About the application

Application number: 2020/93250	
What is the application for?:	Outline application for erection of residential development
Address of the site or building:	Land to the Rear of, 196, Cowlersley Lane, Cowlersley, Huddersfield, HD4 5UT
Postcode:	HD4 5UT

STATUS		
PROVISIONAL (OUTINE)		
PROJECT		
216 PLOT		
TITLE		
ELEVATIONS		
CLIENT		
LYNN		
DRAWN BY	CHECKED BY	DATE
Author	Checker	08/21/20
SCALE (@ A1)	PROJECT NUMBER	
1 : 50	HD.20.57	
DRAWING NUMBER	REV	
HD.20.57.PP.03

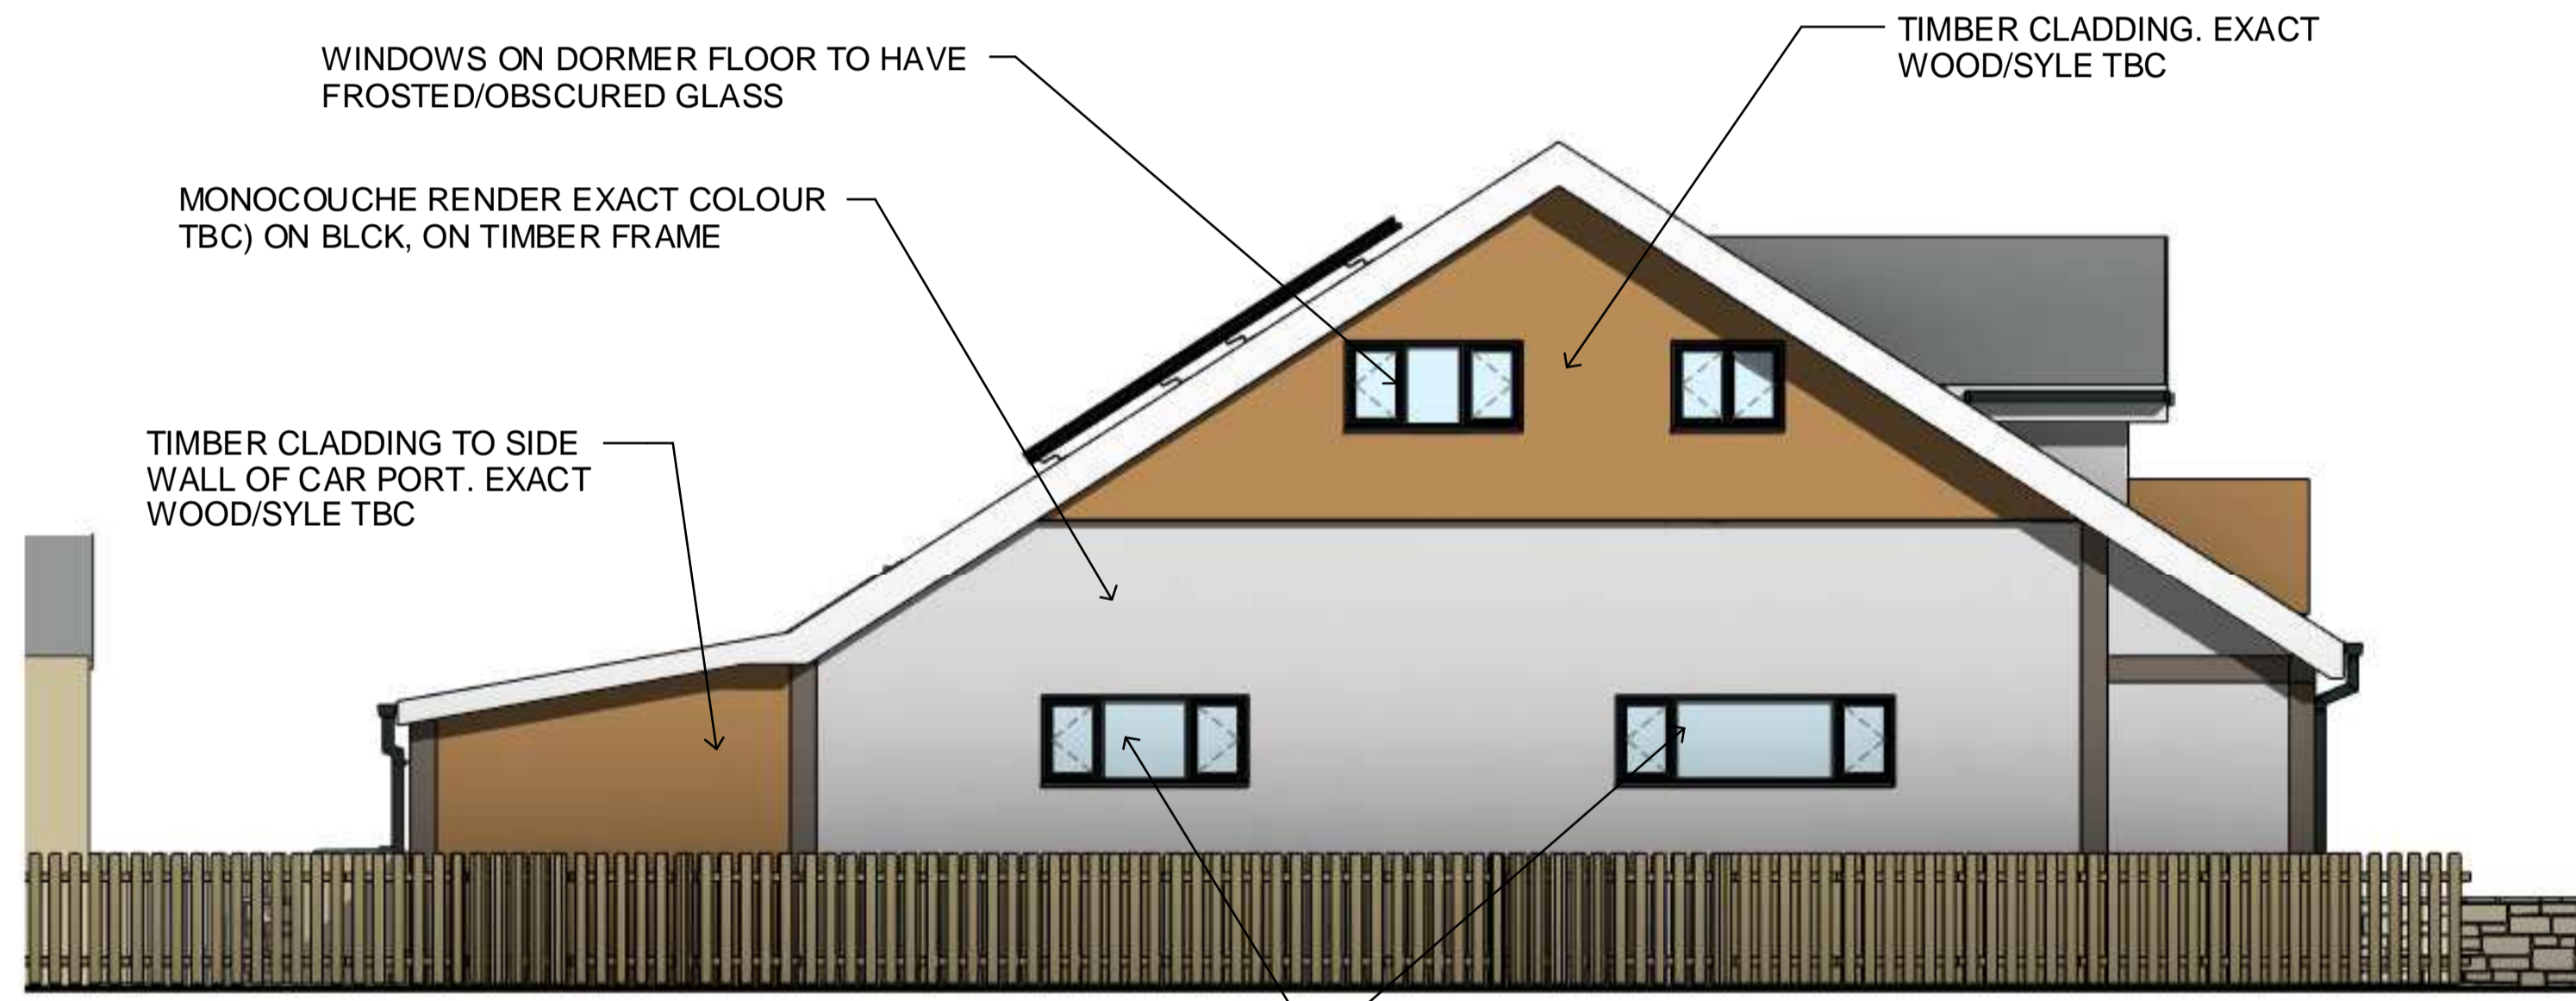
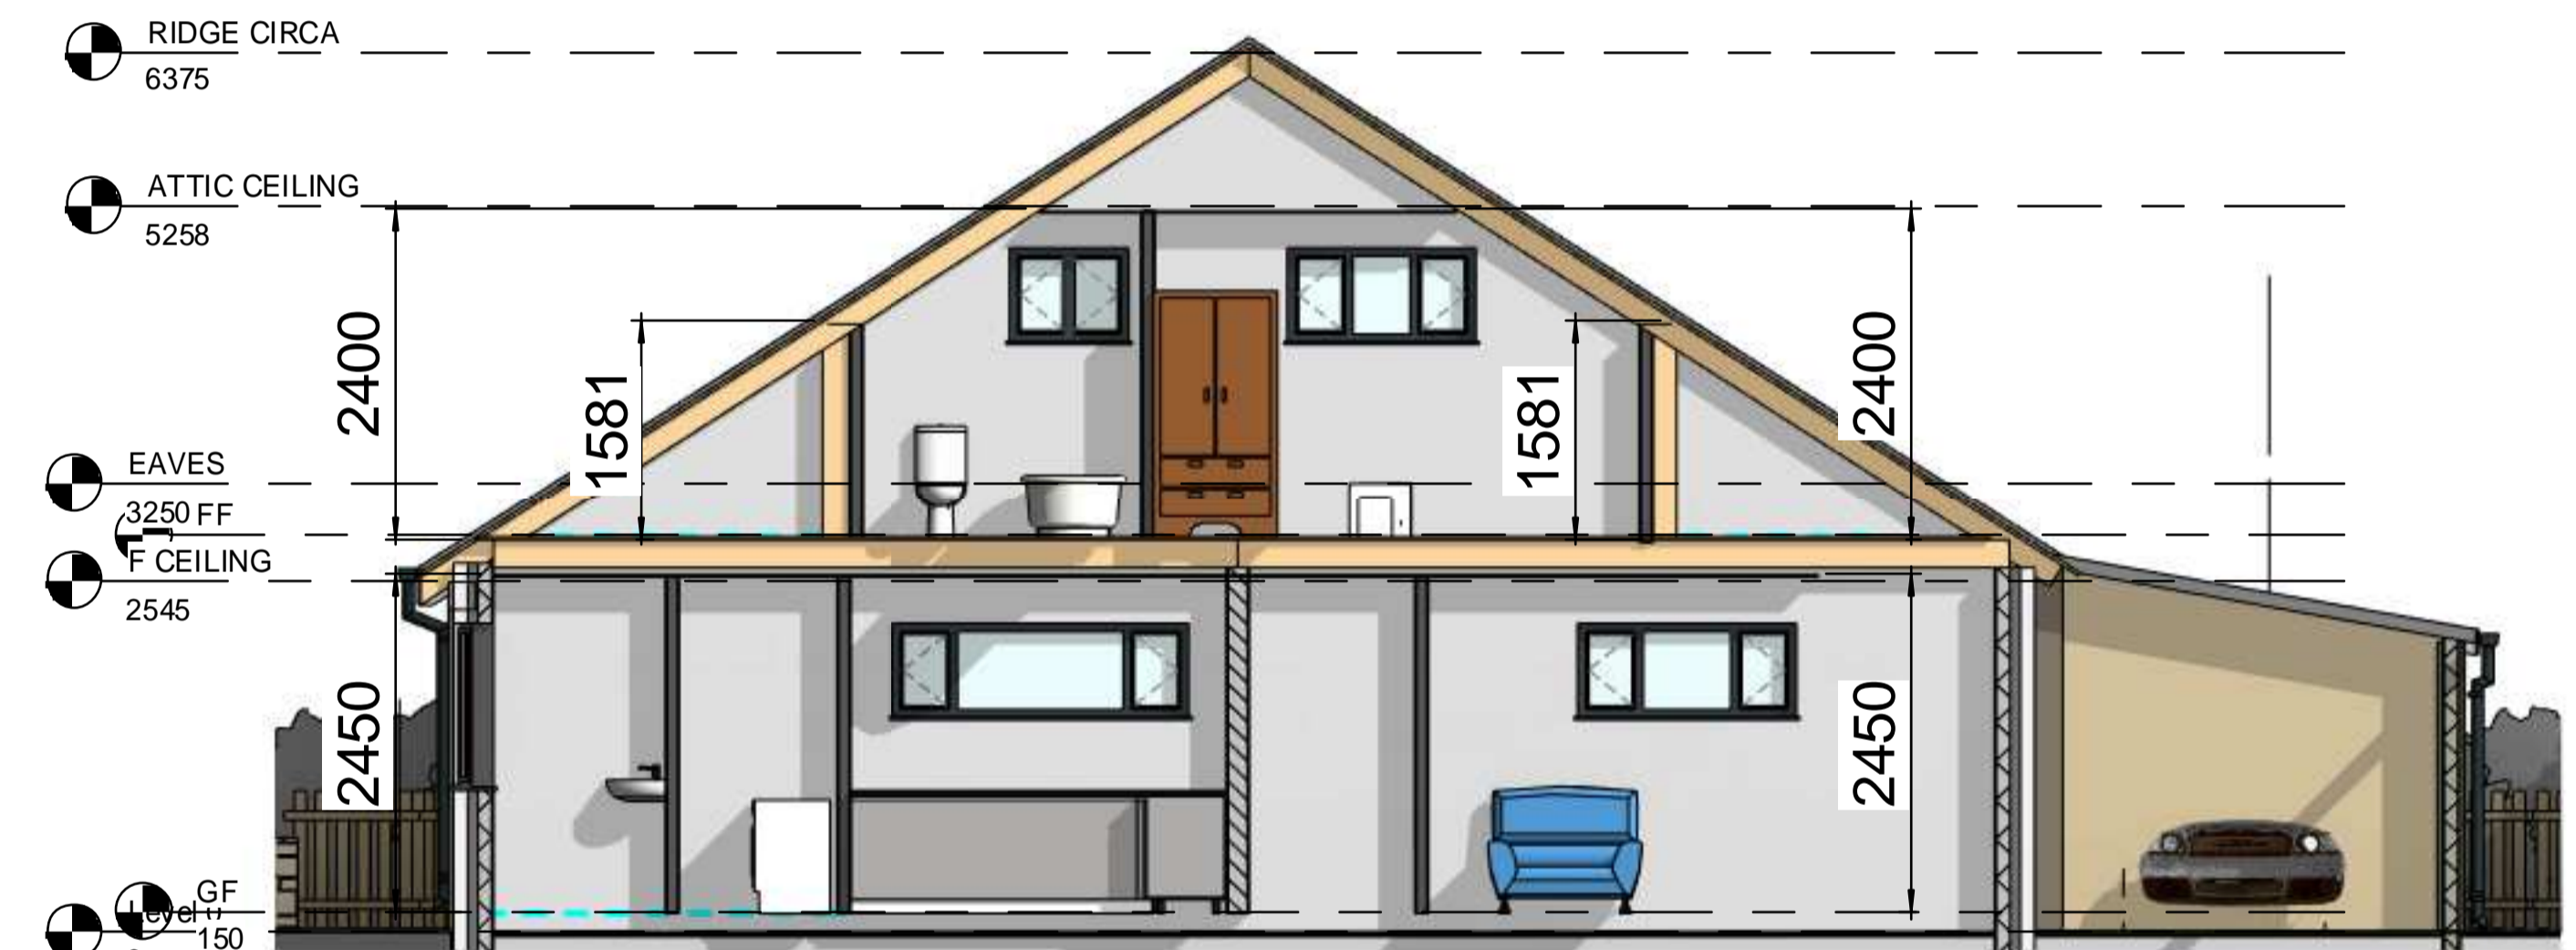
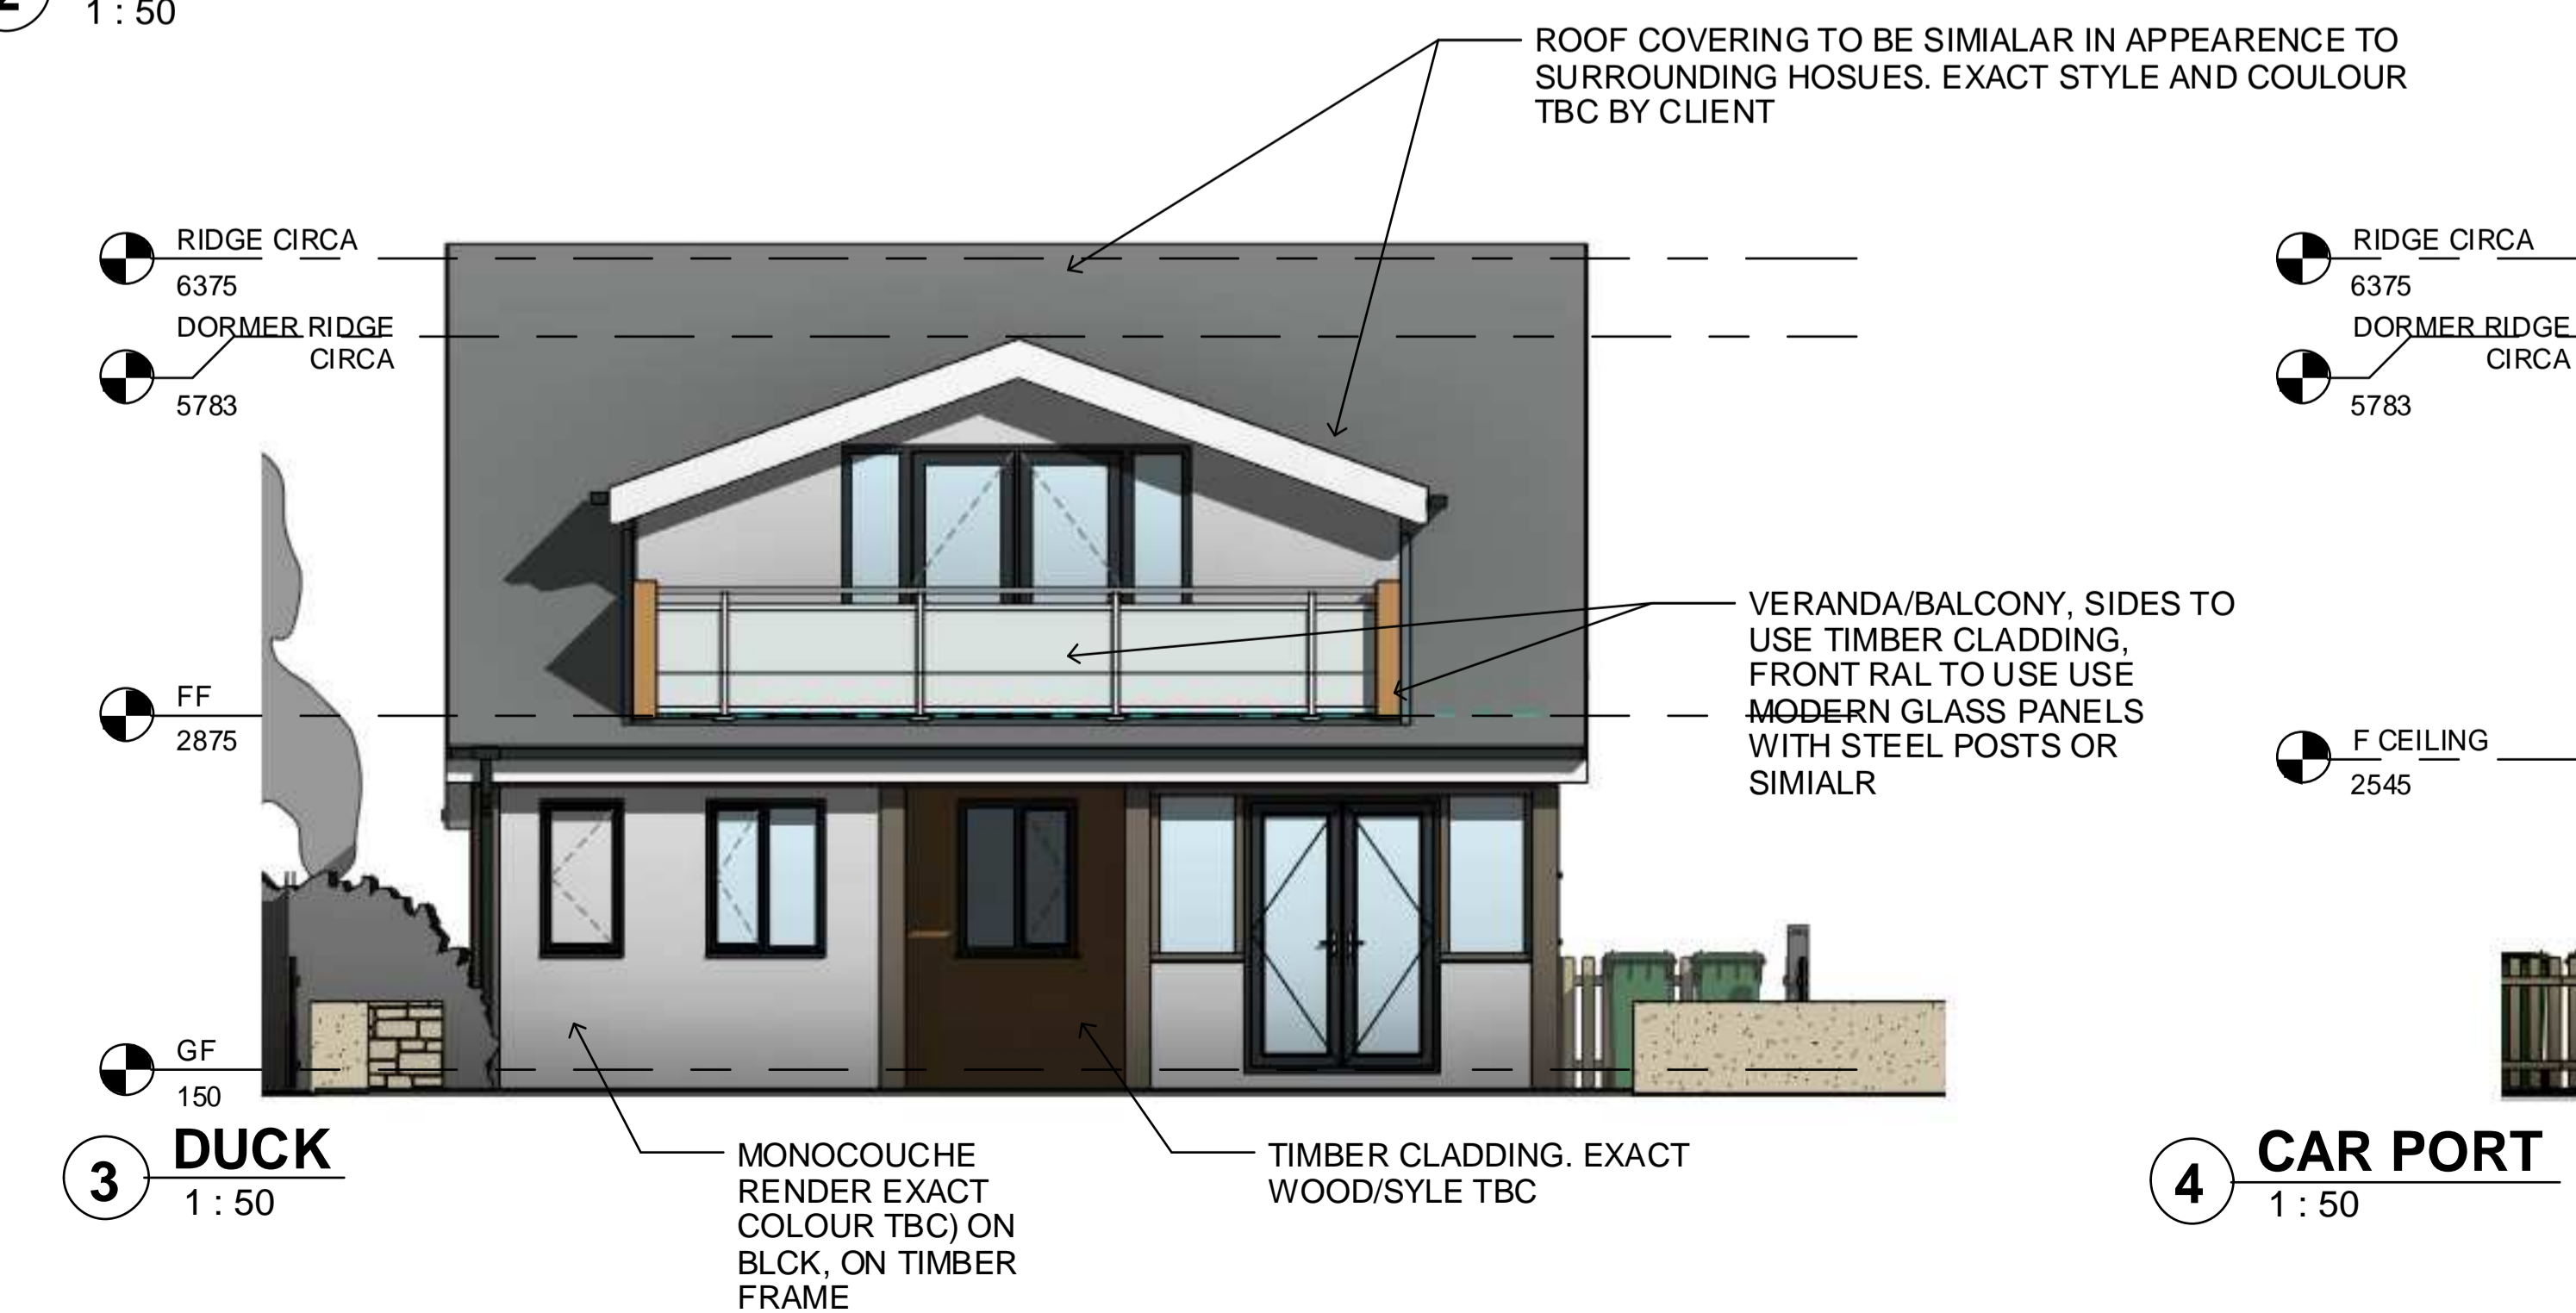
Type of comment: A general comment
1. Concerned about the height of the building, that it will block the light into our garden. 2. Boundary line. Will the building be within the permitted limit which we believe to be one metre? Can it be built up to the boundary line? 3. On looking at the plans submitted we will have 4 windows overlooking our property, 2 on the ground floor and 2 on the first floor. These will invade our privacy. 4. We were advised that the building was to be a 2 bedroomed bungalow, which we have no problem with. Unfortunately the plans show a 4 bedroomed 2 storey mansion with windows overlooking our private garden. We believe the building will obstruct our 'right to light' and the enjoyment of our garden. 5. This property will obstruct our views from our kitchen and dining room which I have enjoyed for the past 20 plus years. We confirm that we are not opposed to the building of a single storey bungalow. Please can you reply with your comments to the above points before 17 December 2020.
